From: Walter Feurer <waleswiss@comcast.net>
Sent: Friday, November 13, 2015 4:51 PM
To: Lindsey Ozbolt
Cc: waleswiss@comcast.net
Subject: Fwd: fyi - RZ-15-00001 Big Creek Trails PUD

RZ-15-00001
BIG CREEK TRAILS PUD
Concerning Big Creek Trails PUD

Illustrative Master Plan
Big Creek
 A Planned Unit Development
 Kittitas County, Washington

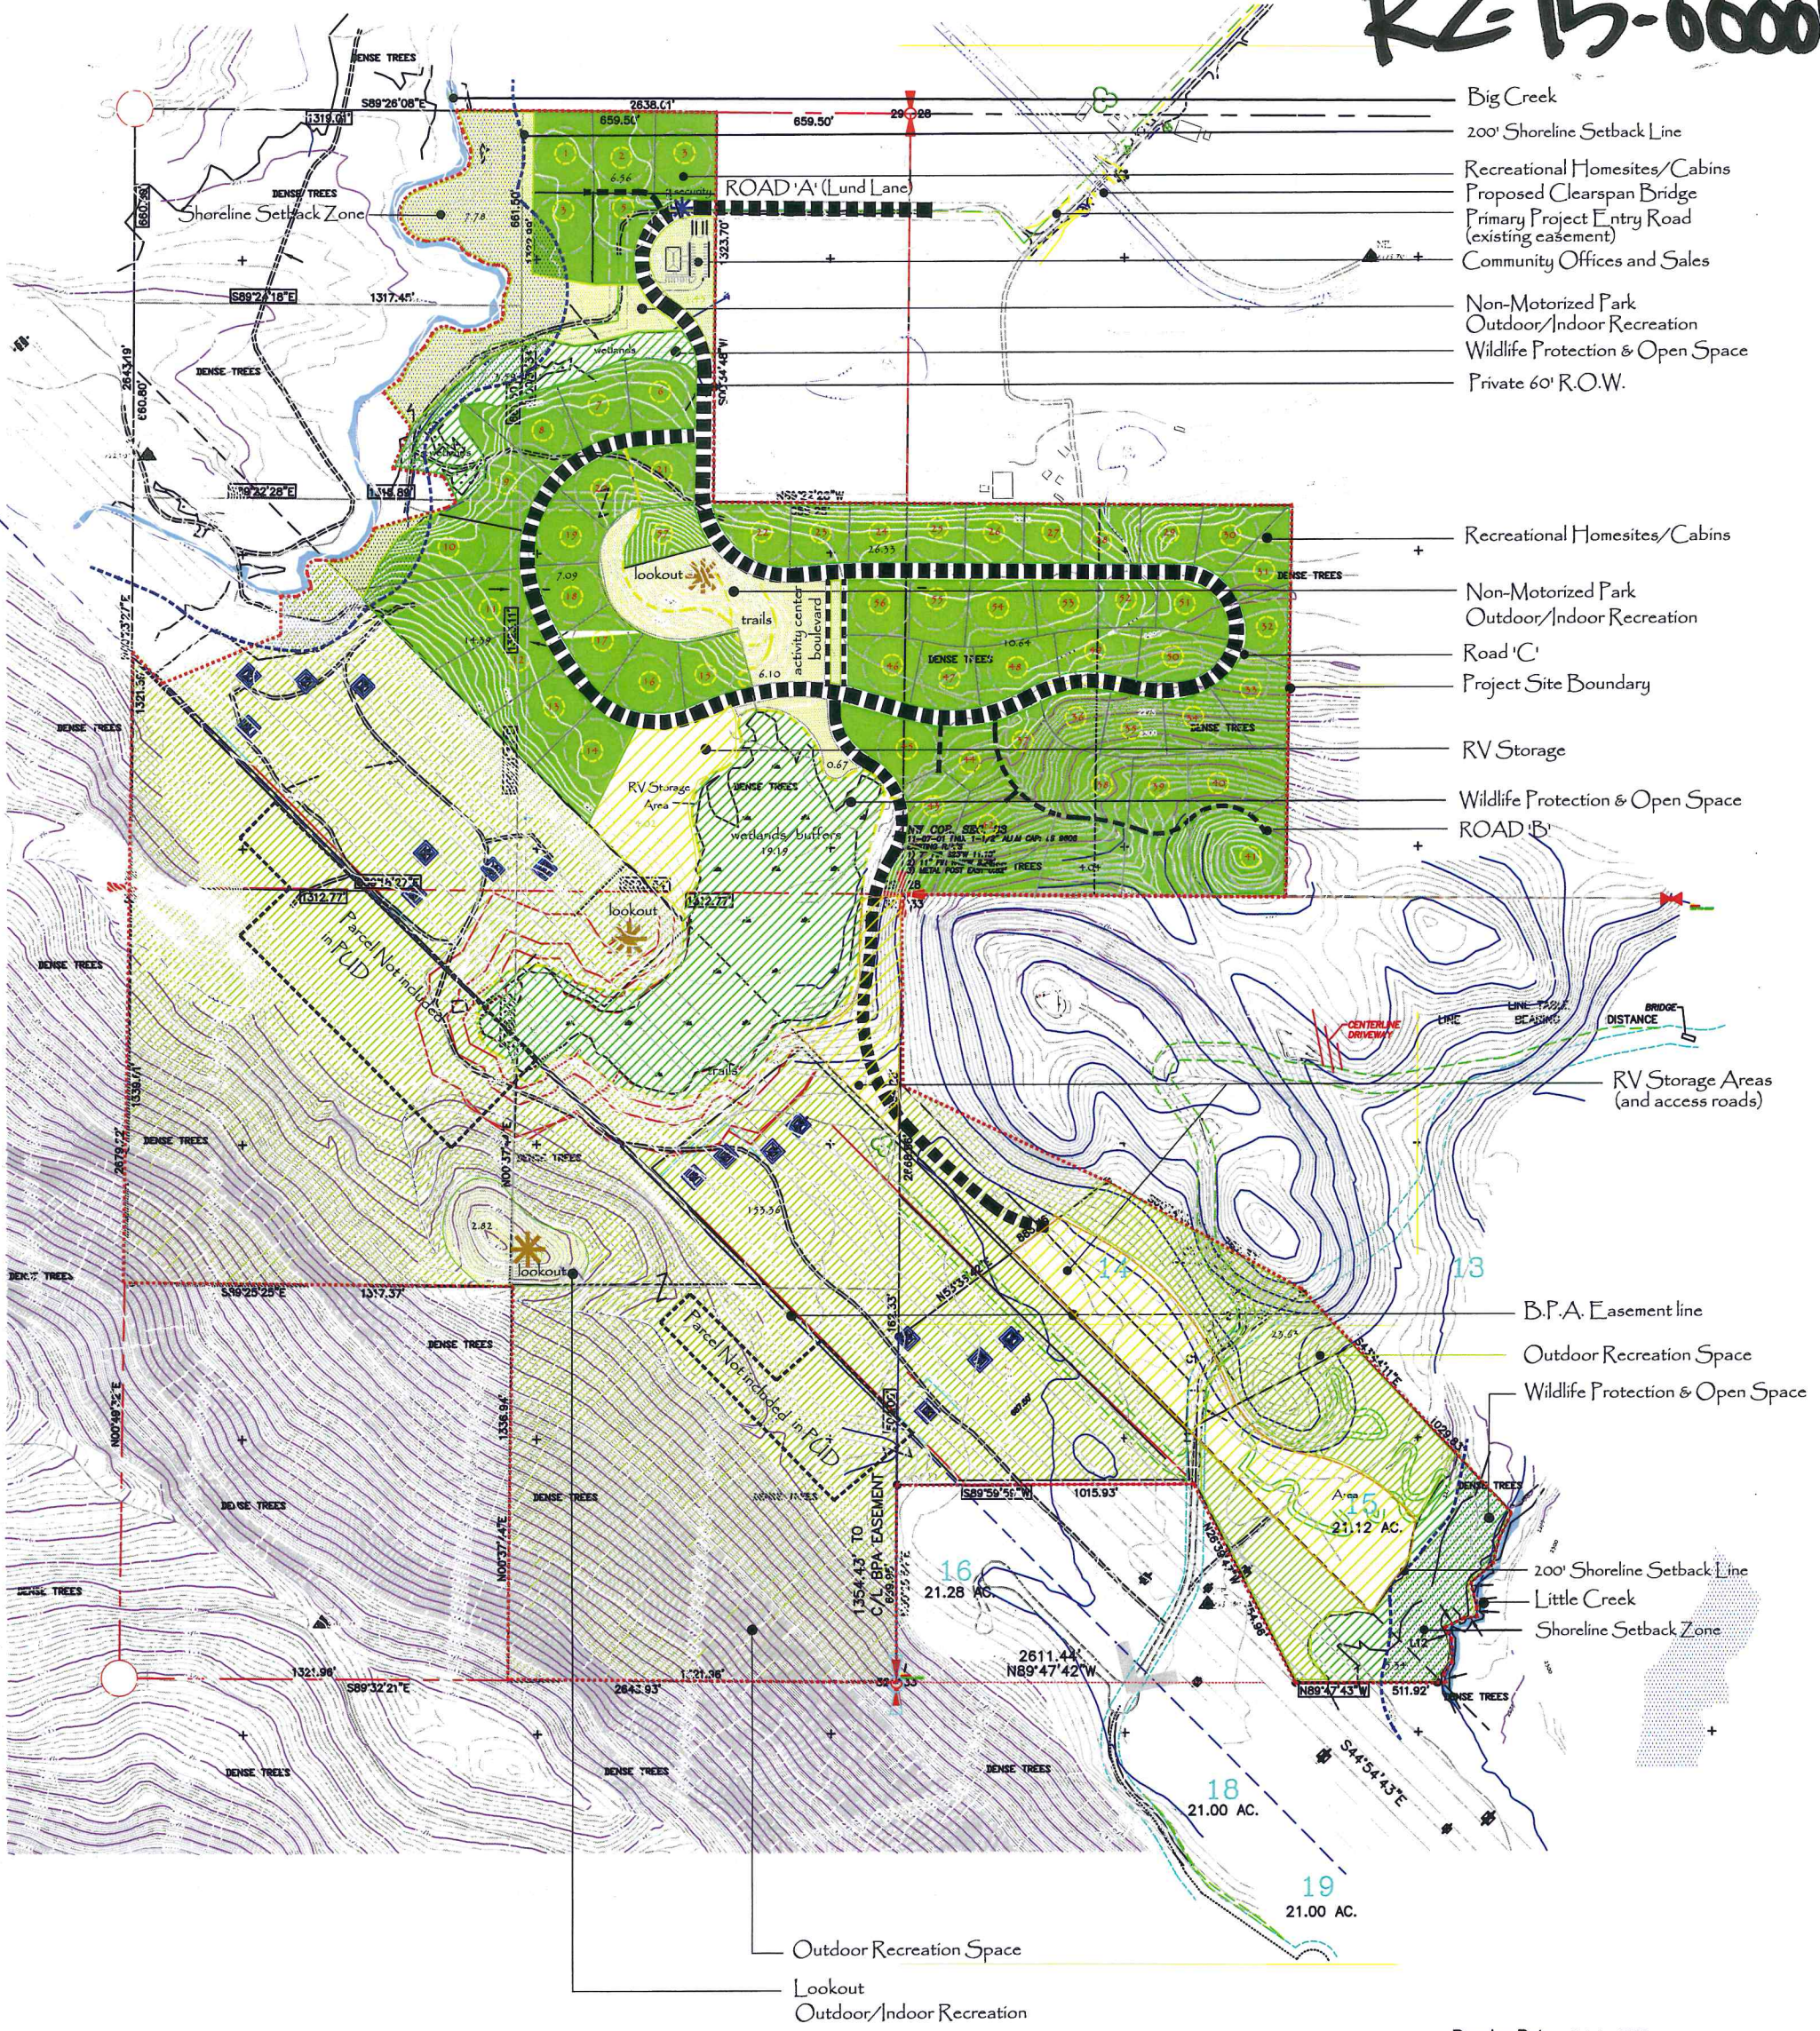
The set back from our Ranch Property looks to be only 25 feet. This is to close to our dance hall facility and it would be unreasonable to build a housing project so close on a 300 acre project. The feel and open look of nature is what our campers come to enjoy. Not a small city for profit. BIG CREEK TRAILS PUD have hundreds of acres. Please put a barrier/ green belt so we and our guest can enjoy the country not the city feel of the area. This housing development really does not fit in this area. Too many houses stuffed into not enough land.
